Application No: FP/70/21/PL
Site Address: Kenwood Court 6 The Midway Felpham PO22 7EZ
Description of works: Erection of a car port and rearrangement of existing parking spaces. This application is in CIL Zone 4 (Zero Rated) as other development.

Thank you for your internet representation made on 19th May 2021 which has been recorded as an objection with the comments as follows:

**PROPOSED CAR PORT
PLANS AND ELEVATIONS**

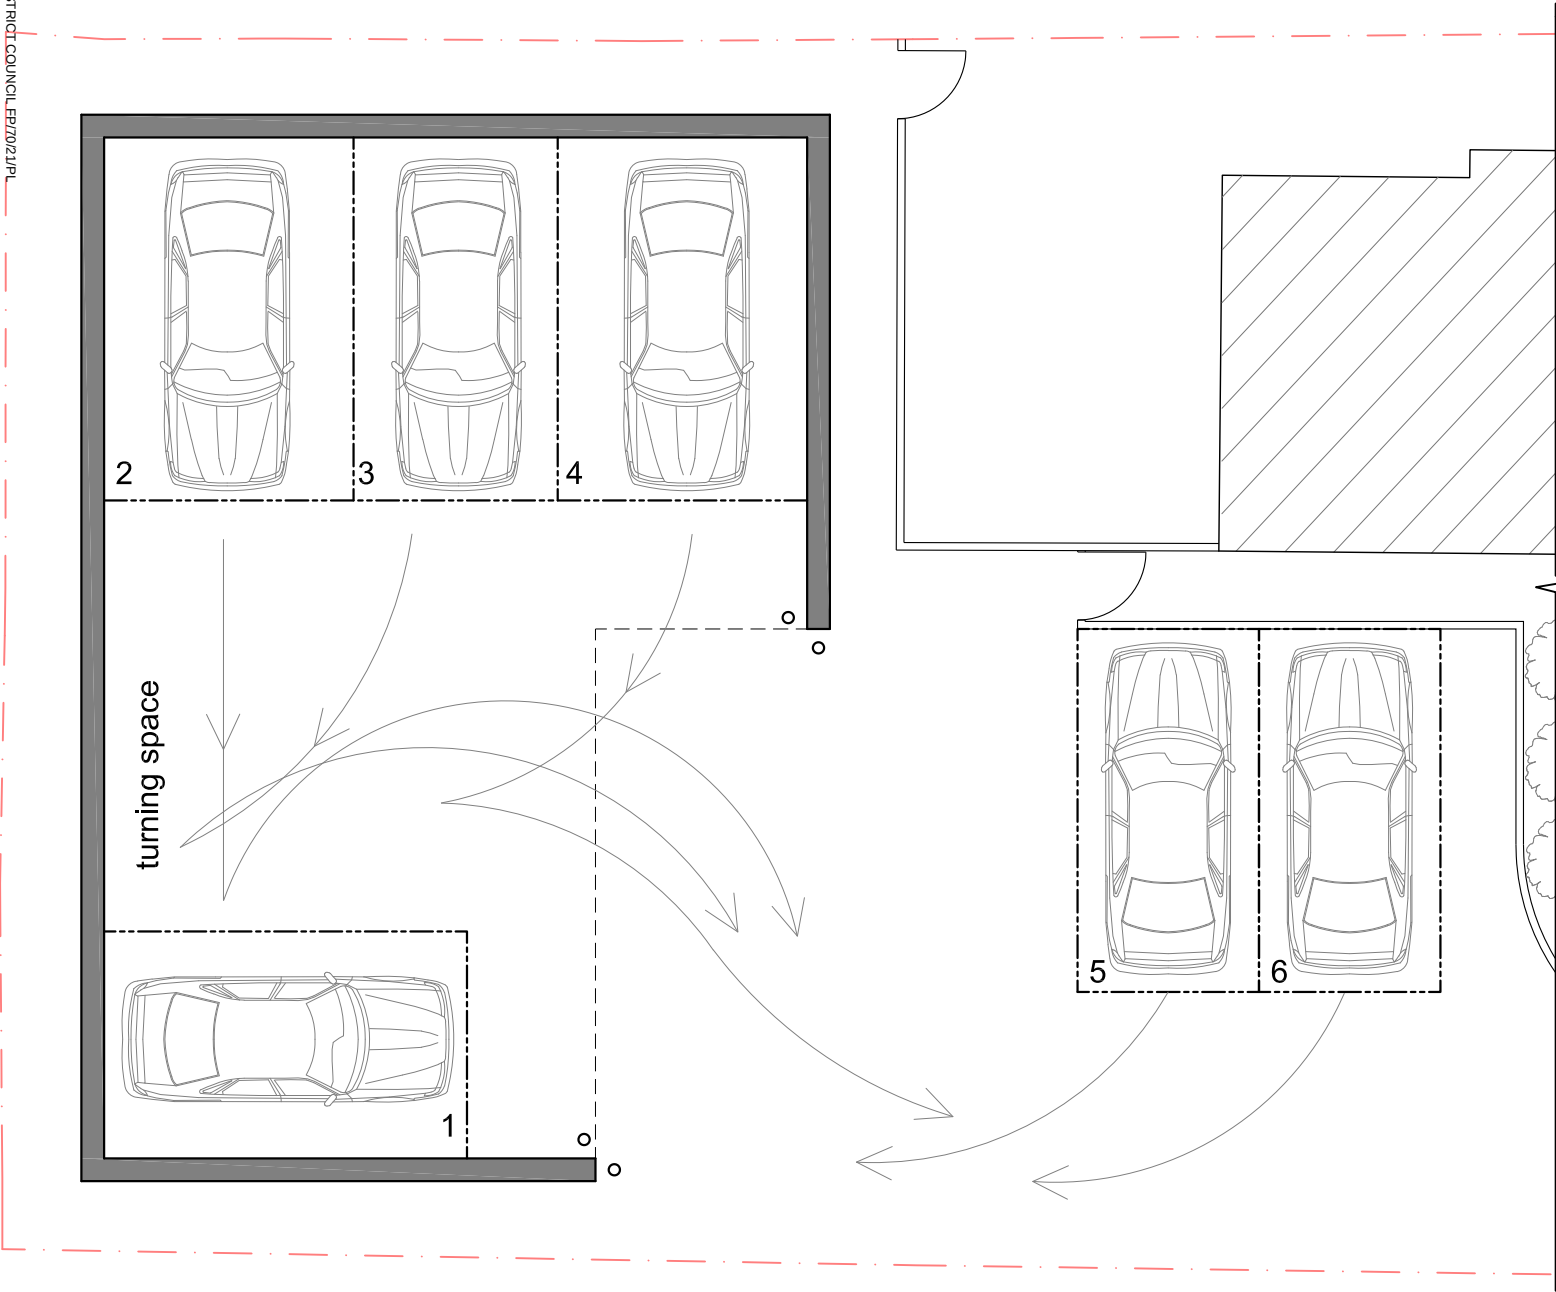
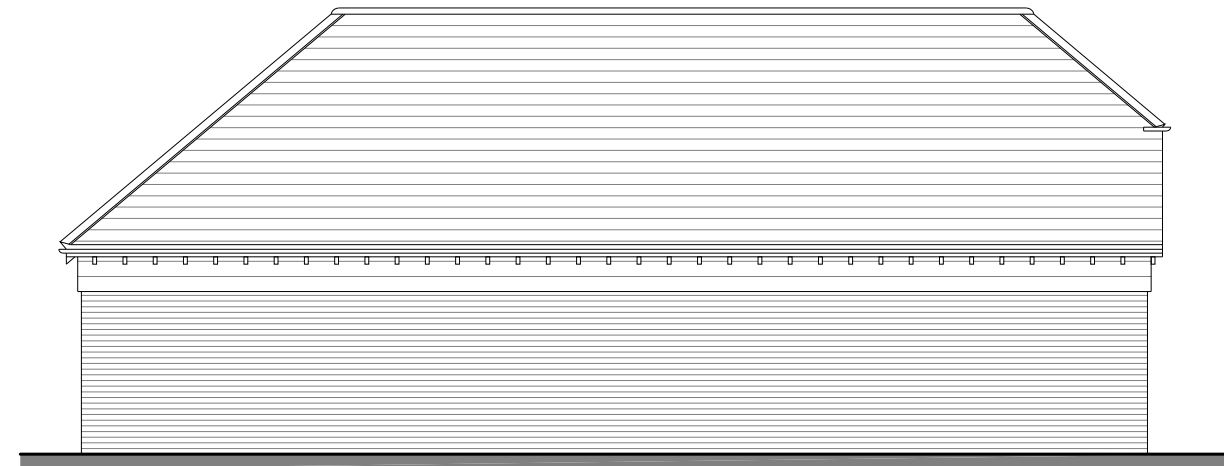
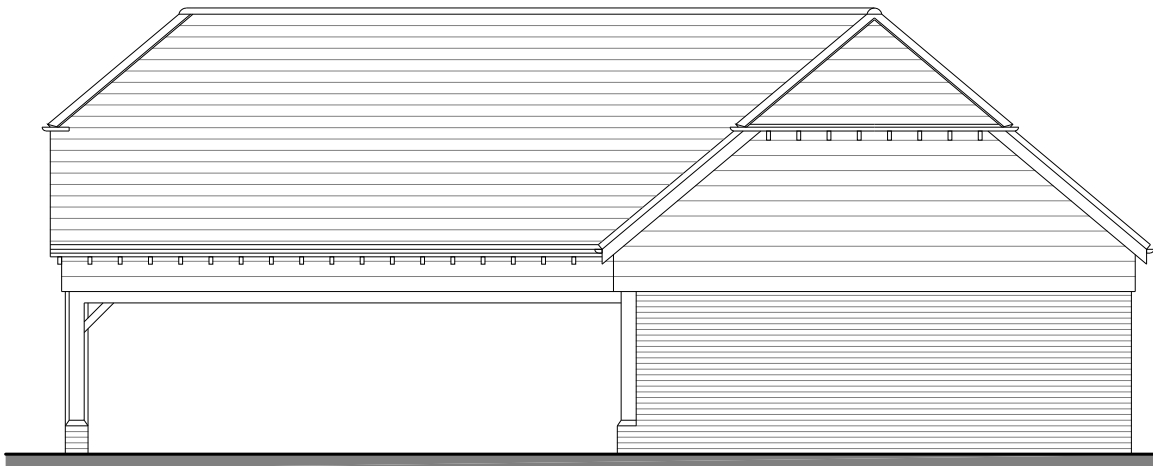
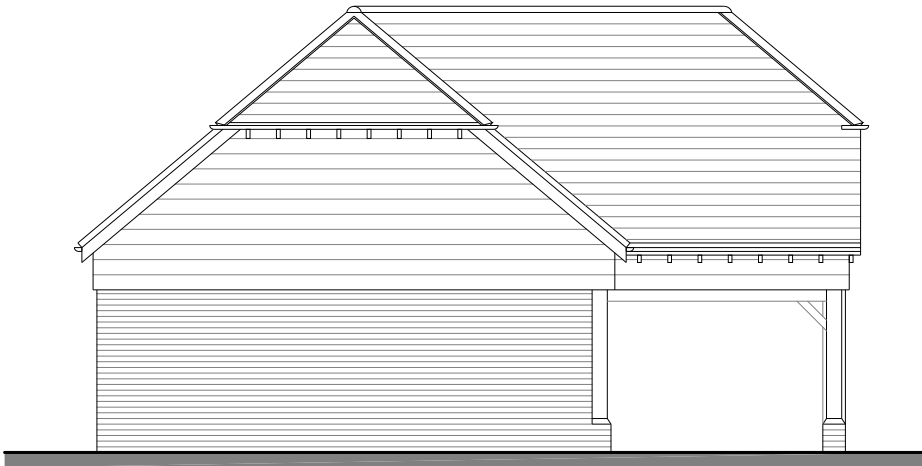
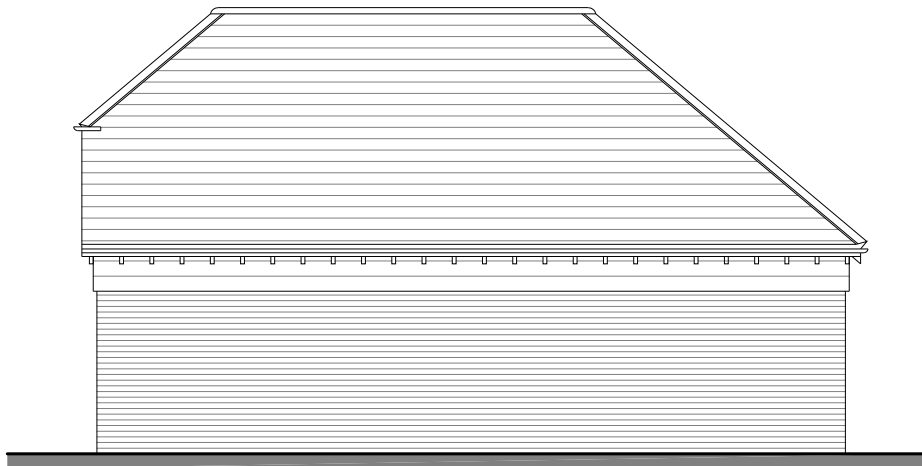
There has been NO notification outside the property showing the planning permission. The height of the proposed car port would block our view from the front room and block out the sun to the garden.
